**Our ref:** RA/2023/146640/02-L01  
**Your ref:** 2023/93539

**Date:** 03 April 2024

**OUTLINE APPLICATION, INCLUDING THE CONSIDERATIONS OF ACCESS APPEARANCE, LAYOUT, AND SCALE, FOR THE ERECTION OF A SIX-STOREY BUILDING TO HOST 76 RESIDENTIAL APARTMENTS (C3 USE) AND ANCILLARY WORKS COMPRISING DEMOLITION OF VACANT BUILDING, FORMATION OF NEW ACCESS, PARKING AREAS, OPEN SPACE AND LANDSCAPING; ERECTION OF CYCLE AND BIN REFUSE STORAGE STRUCTURES – LAND ADJ, LEDGARD BRIDGE MILL, BACK STATION ROAD, MIRFIELD, WF14 8NZ**

Project	Proposed residential scheme at Ledgard Bridge, Mirfield
Client	Binks Executive Homes Ltd, Cawthorne, Barnsley S75 4EJ
Dwg Title	(17001)10_Elevations
Scale	1:200 @ A1
Date	Jan 22

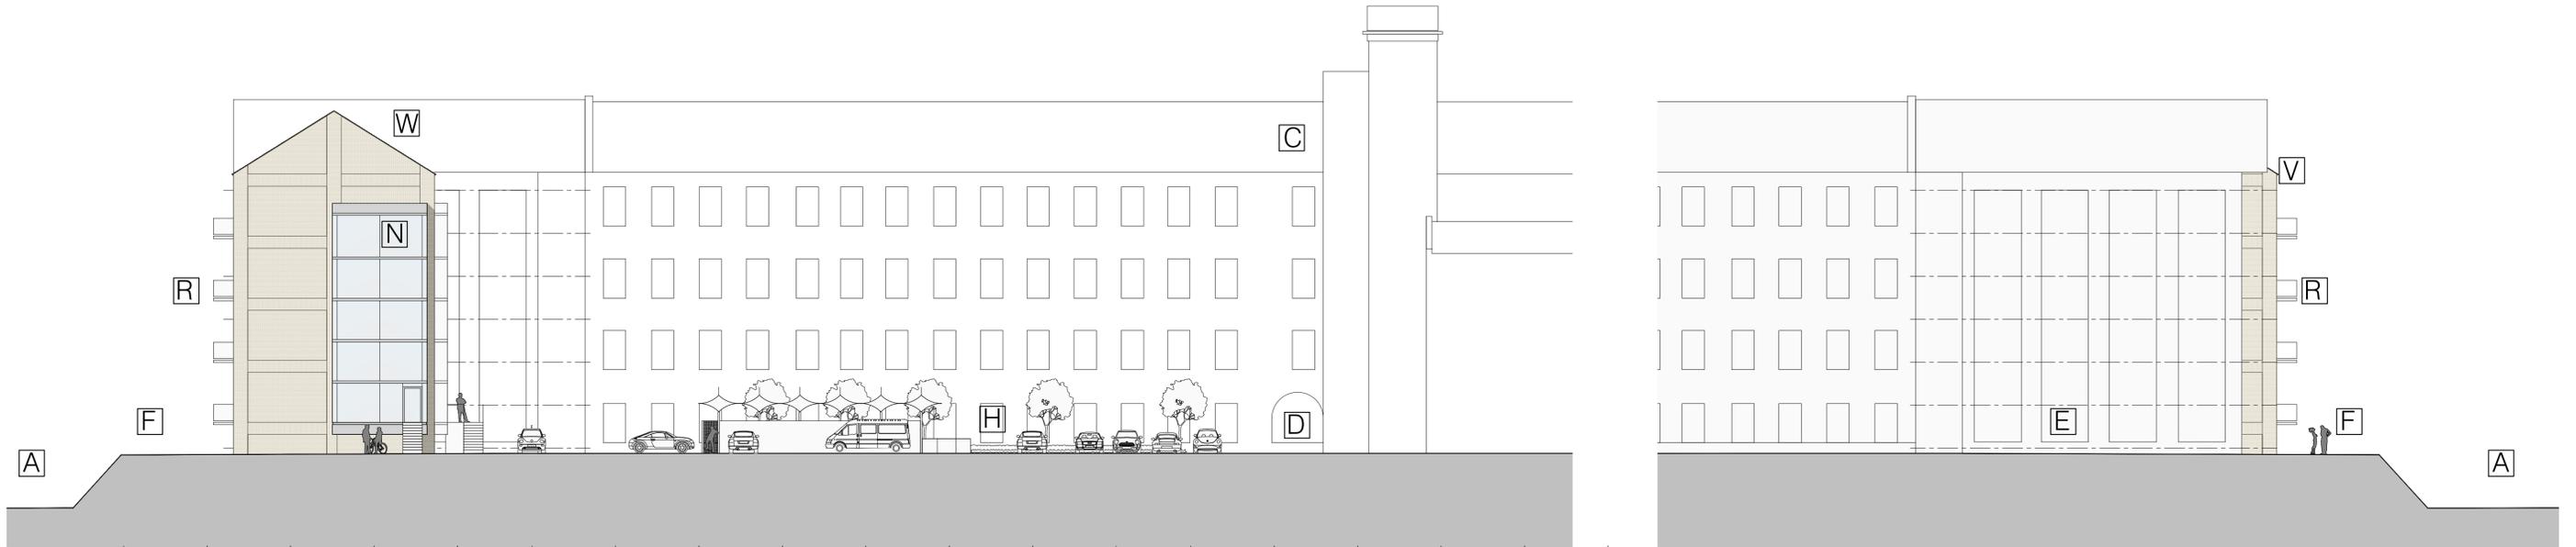
- As per point 1, the proposed stilts and voids aren't considered to be a suitable way of maintaining floodplain storage volume on site. This was covered in previous correspondence.

- As no finished floor levels have been specified and the proposed stilts and voids solution isn't considered acceptable, we aren't able to conclude that site users will be safe on site during a flood.
- As the site would flood during a design flood event, safe access and egress would rely on suitable emergency procedures. We do not review or approve emergency procedures, but we do need to make sure that suitable information is provided to inform them. This includes information on depth, velocity, and hazard rating. These have not been provided in full, so we aren't able to advise the emergency planners appropriately.
